Please ask for: Ms Iqraa Malik  
Email: [iqraa.malik@terraquest.co.uk](mailto:iqraa.malik@terraquest.co.uk)  
Telephone: 01212341390  
Our Ref: FP/242/20/HH  
Your Ref:  
Date: 24th December 2020

**Application for Planning Permission for Works or Extension to a Dwelling**

**Development:** Front single storey extension with balcony over and conversion of garage.  
**Location:** 11 Sea Drive Felpham PO22 7NE

LOCATION (1:1250)

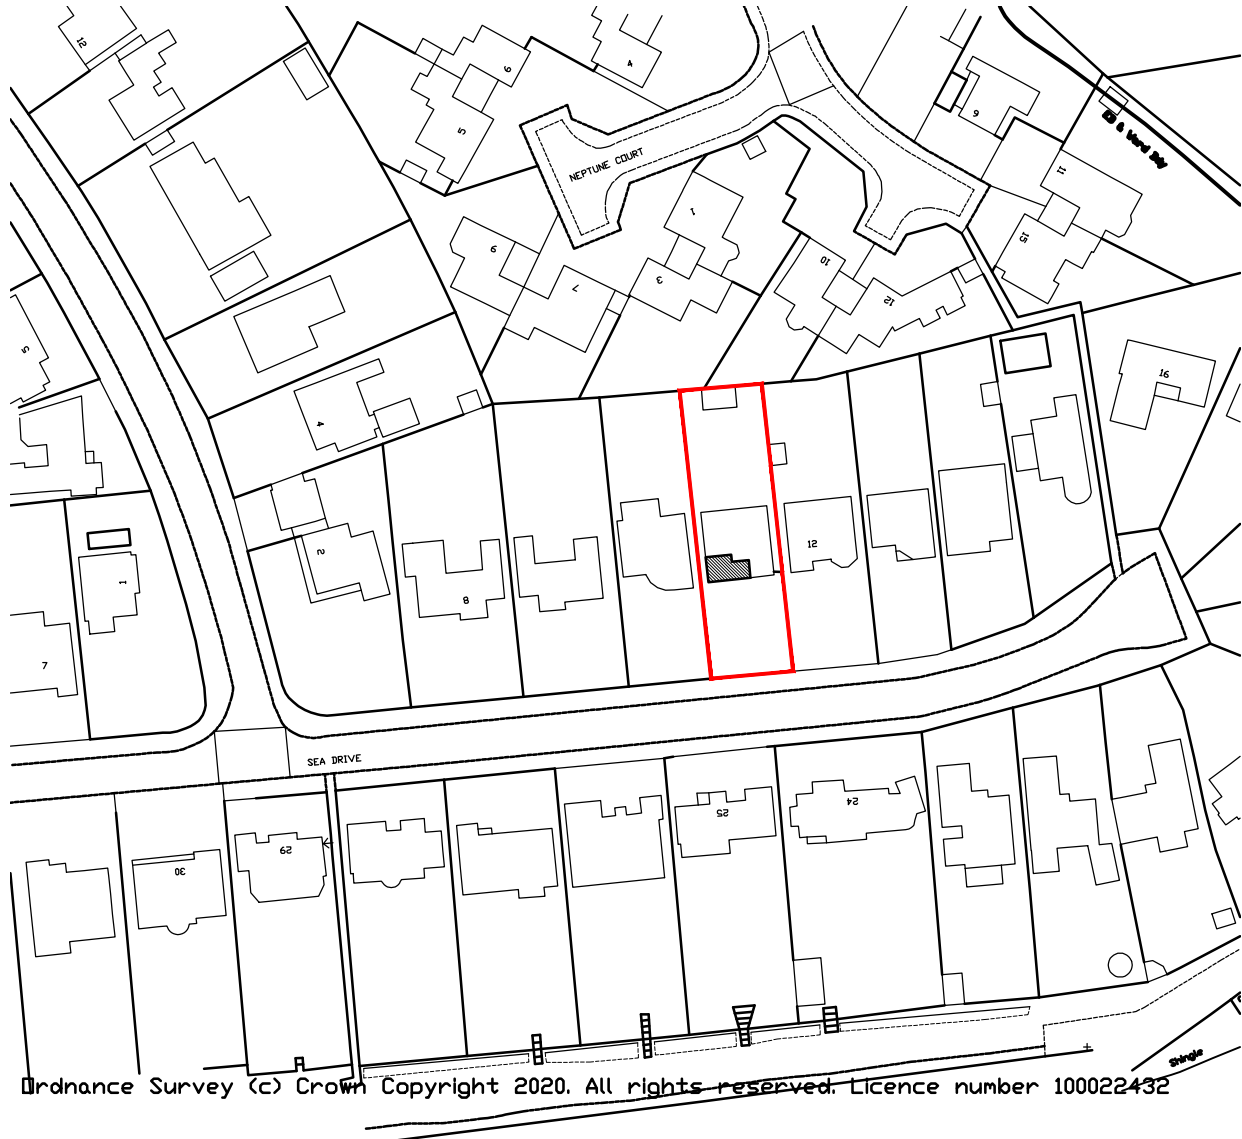
Location Plan: You are required to have a solid red outline around the proposed site on the location plan. Please amend

BLOCK PLAN(1:500)

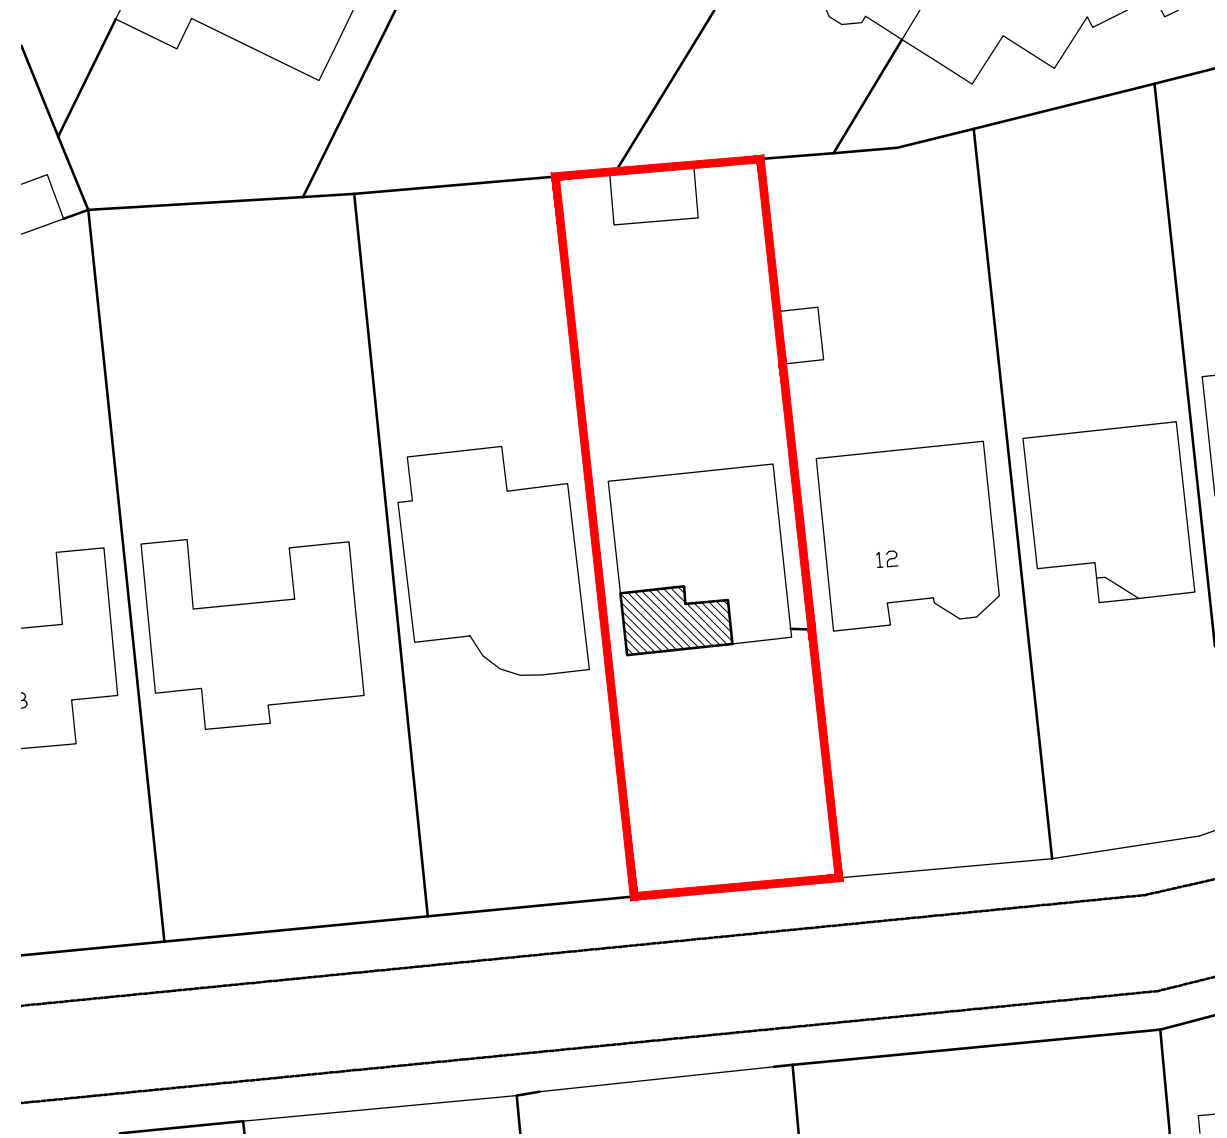
Block Plan: you are required to include dimensions on the block plan from the proposed extension to all site boundaries
